Portishead Branch Line (MetroWest Phase 1)

9.29 ExA.CAS.D4.V1 – Applicant's response to Additional Submission of Mr Stuart Tarr (AS-053)

THE PORTISHEAD BRANCH LINE (METROWEST PHASE 1) ORDER
Applicant's Responses to Mr Tarr's Representations Submitted for ISH 2 and 3 (AS-053)

Drawing file path & name: \\Projects\467470\NSC Framework\2018\BQ.04.20 MW Phase 1 Highway Engineering\BQ.04.20-220\BQ.04.20-220.dwg Rev U.dwg

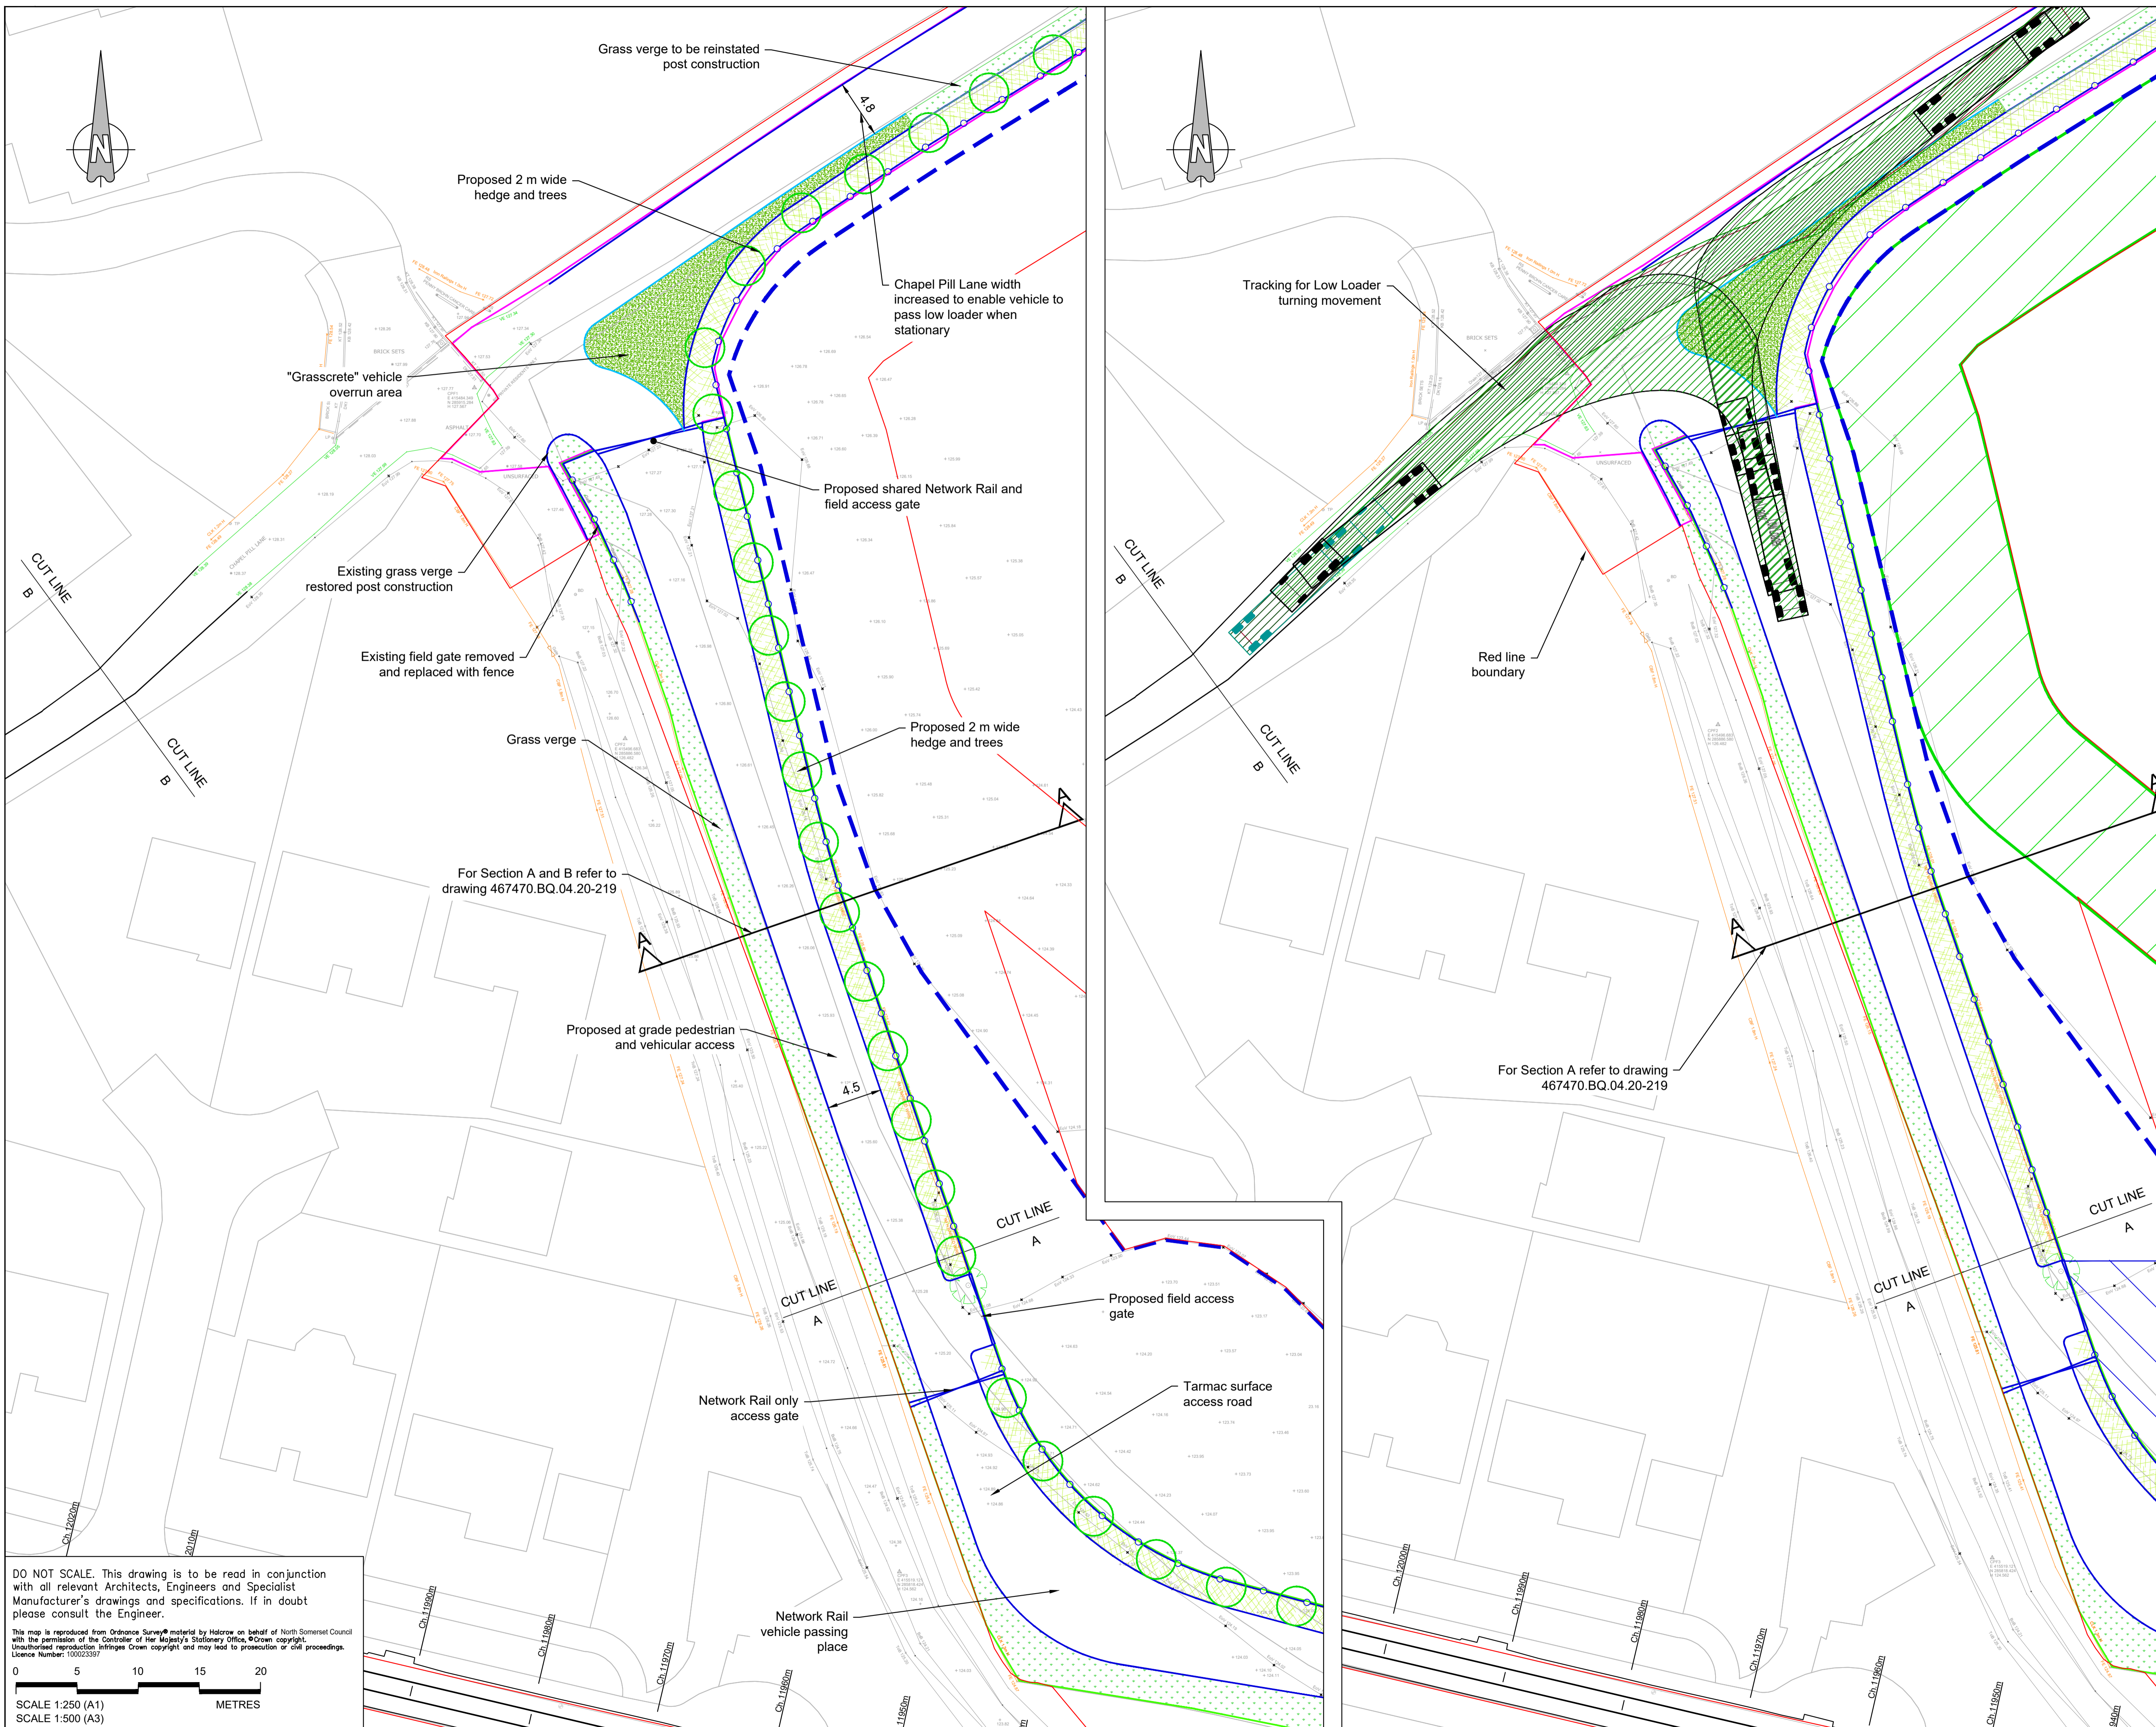
10.	<p>Hearing 2: Construction Practices and Related Matters</p> <p>3.1 Grasscrete is being used for the junction at Chapel Pill Lane so why can this not be used for the track/access road? Why does the access need to be a permanent road surface, especially as</p>	<p>3.1 The area of 'grasscrete' (used here as a generic term to describe a reinforced grass surface that allows vehicles to track over the surface) at the junction is to allow for a low loader vehicle to manoeuvre onto the access track to the compound whilst maintaining the appearance of a grass verge. See APP-040 / 2.45 - 2.46 - Ham Green Highway Works Plans and Pill Tunnel Eastern</p>

Ref.	Mr Tarr's Question	Applicant's response
	<p>the previous access track since dismantled was able to accommodate heavy goods vehicle (HGV) movements with a temporary surface for the repair and upgrade works to the Pill Tunnel when re-establishing the rail freight line? Moreover, this would result in a more sustainable solution to protecting the openness of the Green Belt, its visual amenity, and protecting the bio-diversity of lake?</p> <p>3.2 Secondly, how often will the track be used for essential maintenance and drainage at the Pill Tunnel, for track inspections etc, and what vehicles will be required? Presumably, if there are frequent HGV movements, it would be inappropriate on highways and pedestrian safety grounds and would conflict with Network Rail's own safety regulations to share the access with the proposed social housing development referenced in the Neighbourhood Plan and which, for that reason, should be refused (see also the Applicant's response to Representations at the Open Floor Hearing Held on 19 October 2020)?</p>	<p>Portal Compound, Landscaping and Access Plan Drawing 467470.BQ.04.20-221, which shows the manoeuvre being catered for.</p> <p>'Grasscrete' is not considered appropriate on the access track as the track is also required for emergency access to the tunnel portal. Owing to the relatively steep slopes, a tarmac surface finish is considered appropriate to ensure vehicles do not skid on a grassed surface.</p> <p>The width of the access track has been minimised to 'single' lane with a passing place, and screened with a 2m wide hedge and trees.</p> <p>The temporary construction compound in this location is primarily to enable the construction of the access itself.</p> <p>3.2 Usage will be for inspection maintenance and emergencies. There will be visual track inspections and checking of the silt buster and pump for Pill Tunnel. These inspections could be weekly and 2-3 vehicles could be expected. Maintenance access will mainly be by vans or pickups. Larger vans/small trucks will only be required when works are planned that require RRV's or materials. Larger vans/small trucks should be expected circa two or three times a year.</p> <p>The adequacy of access for the housing development will be for the LPA to consider at the appropriate time. The Applicant for this Order is not in a position to comment on the proposals for access for that proposal.</p>

Figure 6 - Ham Green Construction
Compound
APFP Regulation 5(2)(a)

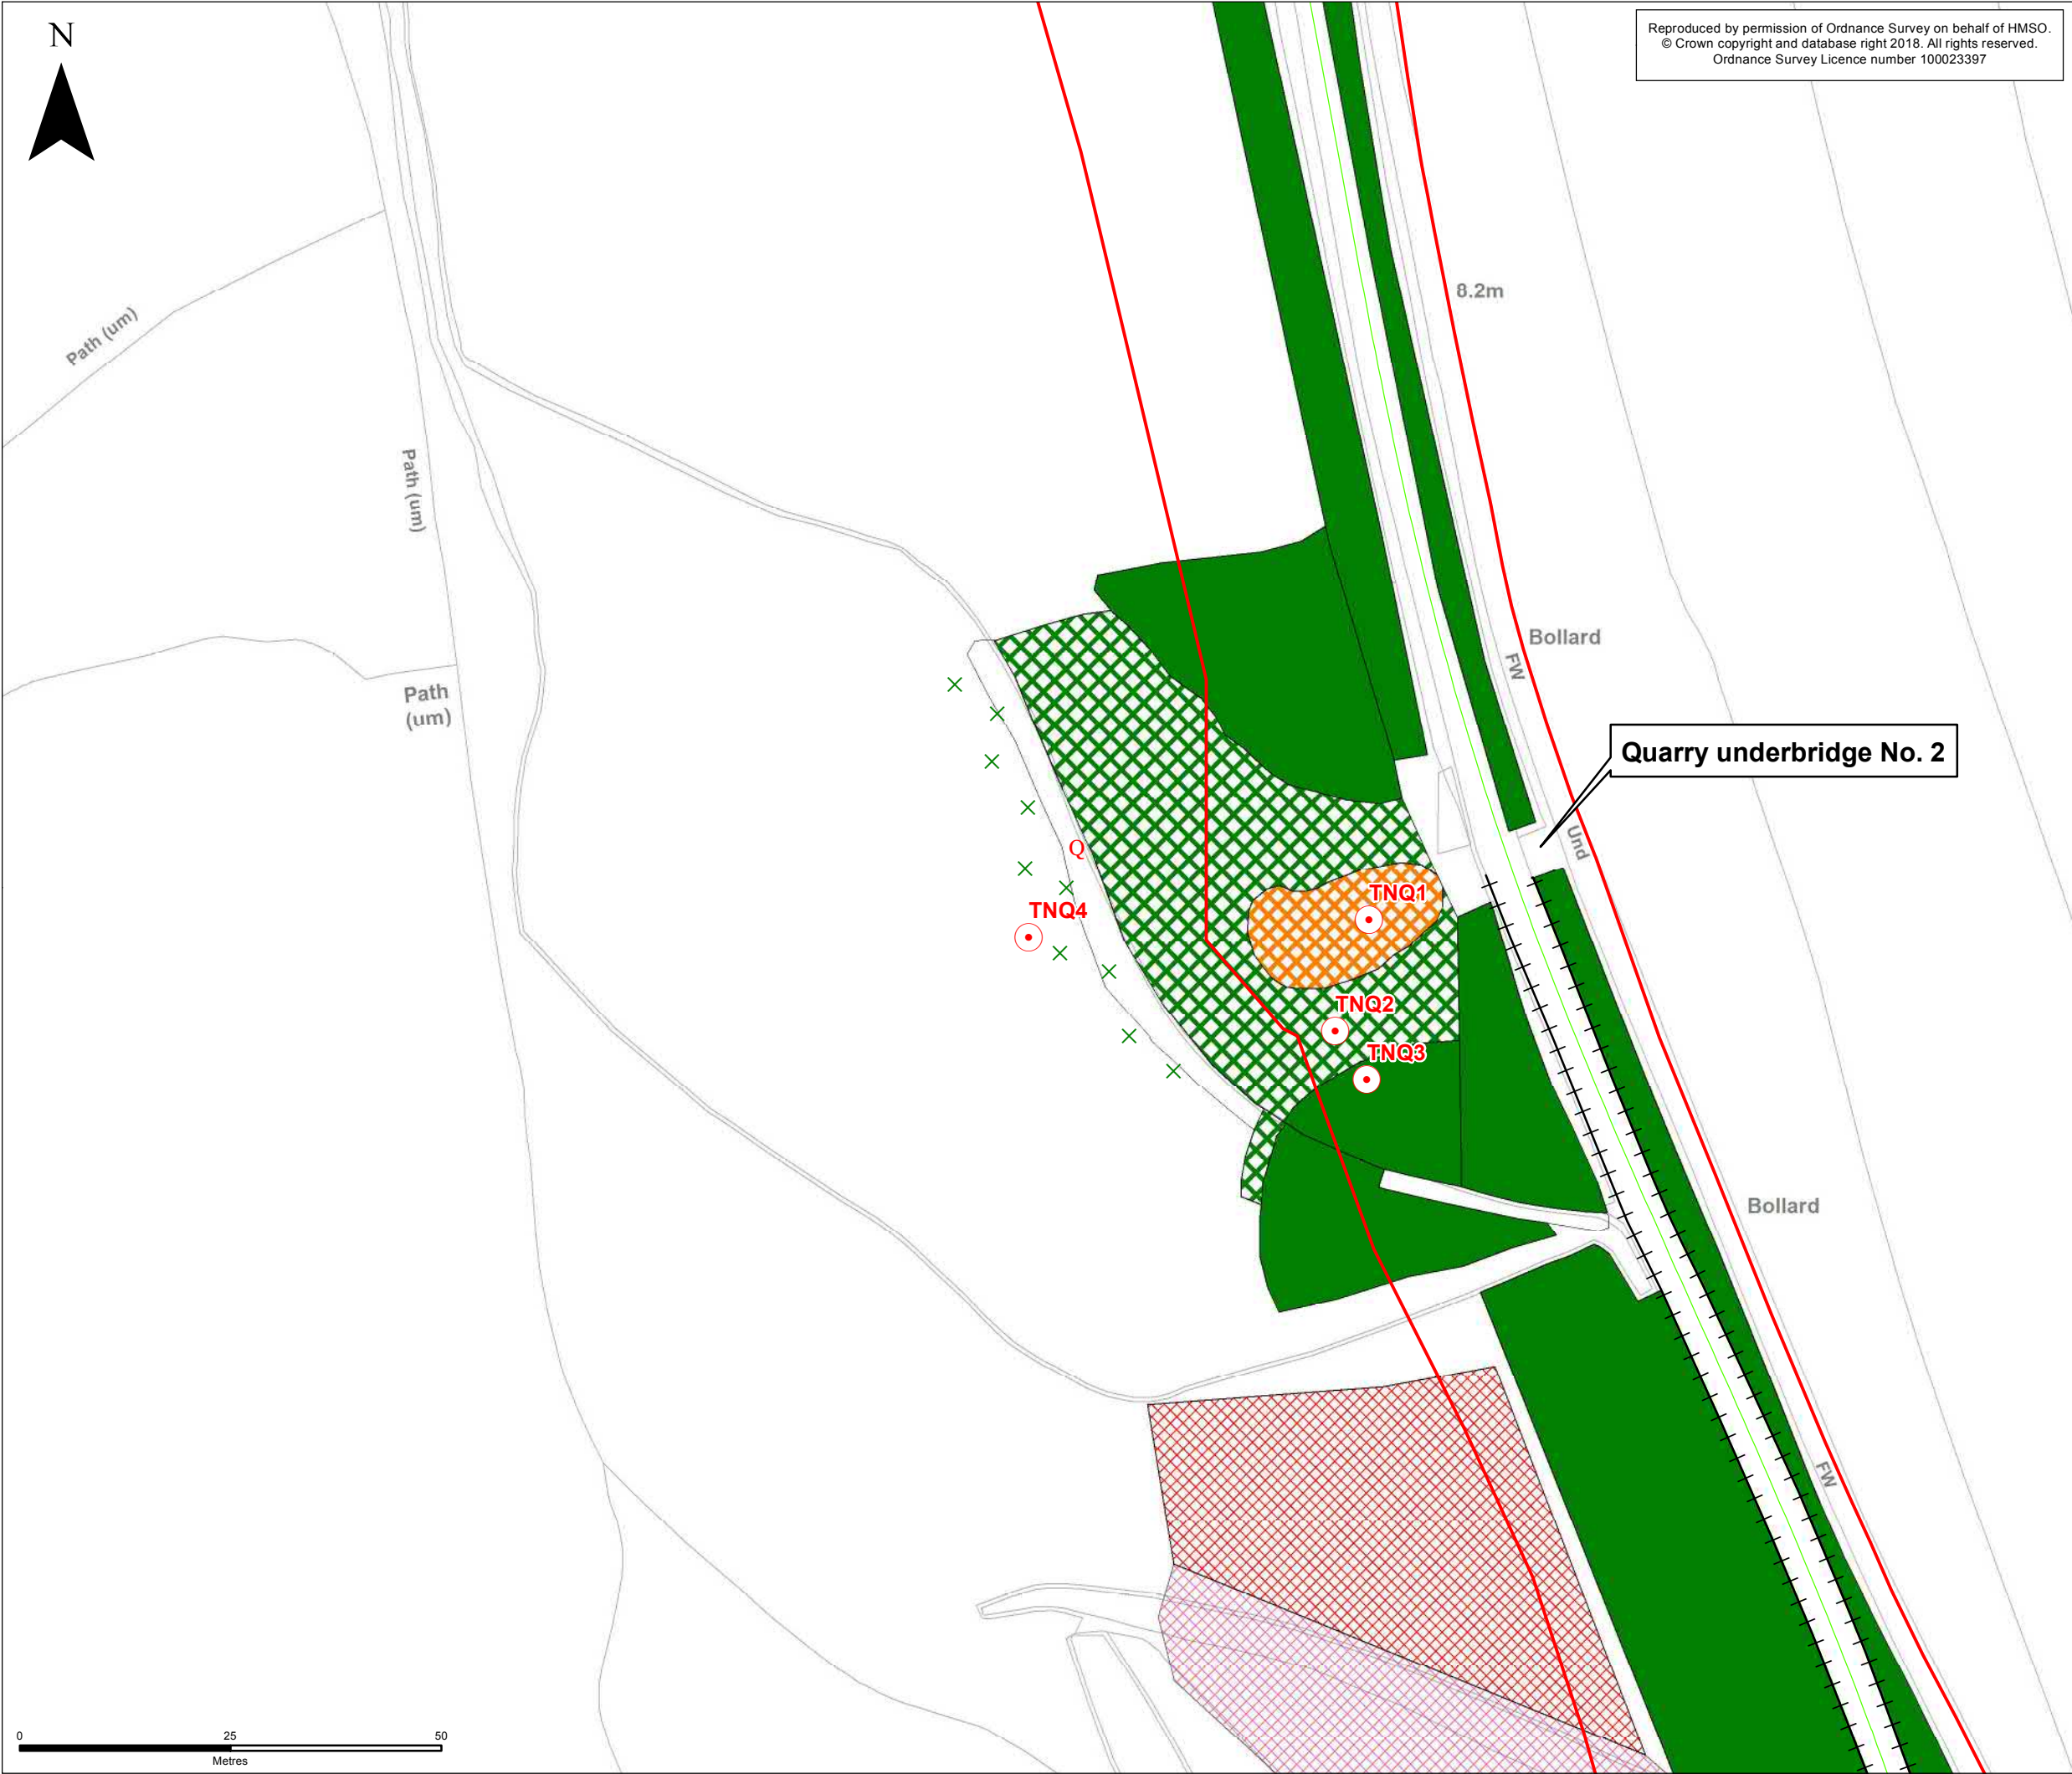
Ref.	Mr Tarr's Question	Applicant's response
2.	<p data-bbox="226 308 781 395">2.1 Extracts from, and responses to, the Travelwest Extended Phase 1 Habitat Survey</p> <p data-bbox="226 432 781 552">Reptiles 4.5.58 States that 'No reptiles or evidence of reptile present were recorded during the phase 1 surveys march-April 2014 & June 2016'</p> <p data-bbox="226 588 781 767">However, during their survey at the Ham Green Compound 26/05/2016 listed in figure 7, target note HG4 states that an adult Grass Snake was found under a wooden panel; this does not appear to have been covered in the report?</p> <p data-bbox="226 804 781 983">Secondly, have further more recent studies been carried out at Ham Green Lake? Dozens of Slow Worms and Grass Snakes are seen every year, often basking in residents' compost bins and tall grasses adjacent to the lake.</p>	<p data-bbox="804 308 1991 427">Account has been taken of reptiles at Pill Tunnel Eastern Portal construction and maintenance compound in the Reptile Mitigation Strategy, Appendix 9.13 AS-040. Figure 1 of this report shows that displacement of reptiles will be undertaken at the compound. Mitigation is also included in the Master CEMP (AS-046, paragraph 6.2.52).</p> <p data-bbox="804 464 1111 488">Displacement will involve:</p> <ul data-bbox="853 528 1991 743" style="list-style-type: none"> <li data-bbox="853 528 1991 584">• Habitat manipulation to displace reptiles in the active season (April to September inclusive) and overseen by an ecologist. <li data-bbox="853 624 1599 647">• A destructive search will be undertaken after displacement. <li data-bbox="853 687 1991 743">• Existing hibernacula within the construction work footprint will be dismantled and removed in the active season. <p data-bbox="804 783 1991 903">Natural England's standing advice for reptiles states that they should be displaced from sensitive areas by changing the vegetation and translocation should be a last resort. Displacement is considered to be appropriate at this site because there is adequate retained vegetation on the periphery of the compound area.</p>

3.	<p data-bbox="226 1026 781 1414">Great Crested Newts 4.5.15 The Ham Green Construction compound possesses suitable habitat for amphibians and the presence of common toads is likely. The ditch and associated ponding on the opposite side of the bridge may provide suitable habitat for Great Crested Newts as it contains suitable vegetation and known populations are located within 500m of the site. HG13 Connecting ditch with areas of ponding may have potential for Great Crested Newts 25/05/16. It is understood that Toads and Great Crested Newts are present, not just likely, the presence</p>	<p data-bbox="804 1026 1991 1174">Further great crested newt surveys concluded that Ham Green Lakes and the associated ponding detailed in the Phase 1 Habitat Survey are not considered suitable for GCNs (pond number 36, APP-119]. GCNs were identified by eDNA at pond No. 37, which is just over 250m from the proposed Ham Green compound on the other side of the operational railway (referred to as the Portbury Freight Line).</p> <p data-bbox="804 1211 1991 1331">The Applicant is aware of the great crested newt population at St Katherine's school and this is referenced in the GCN survey AS-038 paragraph 4.4.10. The pond lies approximately 300 m south of the Portbury Freight line and is therefore outside the 250m buffer zone required for consideration of GCN licensing.</p> <p data-bbox="804 1367 1991 1422">Mitigation for GCNs will be led by DLL by building new ponds off site plus good practice mitigation measures on site through displacement prior to construction. In addition, the Reptile Mitigation</p>

4.	<p>Otters 4.5.61 - are known to be present within the vicinity of Ham Green Construction compound and a spraint was located next to the railway bridge, during the Ham Green Survey of May 2016.</p> <p>HG9 Otter Spraint found under railway bridge (26/05/2016)</p> <p>Target note 85 (2/4/2014) Large fishing lake with water lily and potential for otter.</p> <p>1.1.9 Records provided by BRERC 2014. Records of otter are present close to the Ham Lakes section near the river Avon.</p> <p>The lake owner has recently erected fences in the lower lake as a preventive measure against otter attack to the fish. Large (5lbs or more) half-eaten fish (Bream etc) have been found abandoned very close to the lake that on further investigation have provided clear evidence of otter attack.</p>	<p>The Applicant is aware of the presence of otters and mitigation and this is included in the ES Ecology Chapter 9 [AS-031].</p> <p>The design of Pill Tunnel Eastern Portal compound [APP-040] includes woodland planting at the eastern side between the compound and Ham Green Lakes to reduce disturbance of otters (paragraph 9.5.10) and the Master CEMP [AS-046 paragraphs 6.2.55 and 6.2.56] includes pre-construction survey and measures to avoid construction disturbance to otters.</p>

5.	<p>Dormice 4.5.35 - There are records of dormice (BRERC 2014) at Portbury common</p>	<p>No dormice were found during the survey at Ham Green in 2015. Further habitat assessments have since been conducted for the Applicant and a draft application for a dormouse licence is currently being prepared to submit to Natural England as required in the Master CEMP [AS-046]. The draft</p>

6.	<p>Bats 4.5.23 - The mature trees at Ham Green construction compound, have a number of features that make highly suitable bat roosts. Cracks are also present within the railway bridge however these are classed as having low potential for bats. See Pic HG10</p> <p>Target note 84-Pill tunnel entrance, potential for bats. Ivy covering wall running up towards the tunnel. 02/04/14</p> <p>Target note 85 Large fishing lake with water lily and potential for otter. Adjacent to the lake is a section of woodland with mature oak trees and potential for bat roosting sites. A number of mature trees surrounding the lake also have splits with potential for bat roosts 02/04/14.</p> <p>Target note 86 Ivy covered maple with Bat potential taken in 02/04/14.</p> <p>Target notes HG6, HG7, HG12 (p156-p158) 2 mature Oaks with Bat Potential, 1 Mature Oak with High Bat Potential.</p> <p>It is understood that this is the oak tree (TPO No.857 dated 2nd July 2004) that the affordable for social rent housing development of 12-16 dwellings proposed in the draft Abbots Leigh, Ham Green, Pill and Easton in Gordano Neighbourhood Plan will, if built,</p>	<p>The trees identified with bat roosting potential will be retained. The two oak trees by the lake (target note HG6 and HG7) are identified to be retained on the compound design plan [APP-040].</p> <p>The oak tree in the middle of the field (target note HG12) will not be affected by the temporary right of access to the lake. The boundaries of the MetroWest project do not encroach onto the TPO within the field.</p> <p>The ash tree at Target note 86 is outside the compound area and will not be affected by the DCO Scheme.</p> <p>Bat surveys of Pill Tunnel have been completed and no bat roosts have been found, as detailed in the ES Ecology Chapter 9 [AS-031], paragraph 9.4.118.</p>
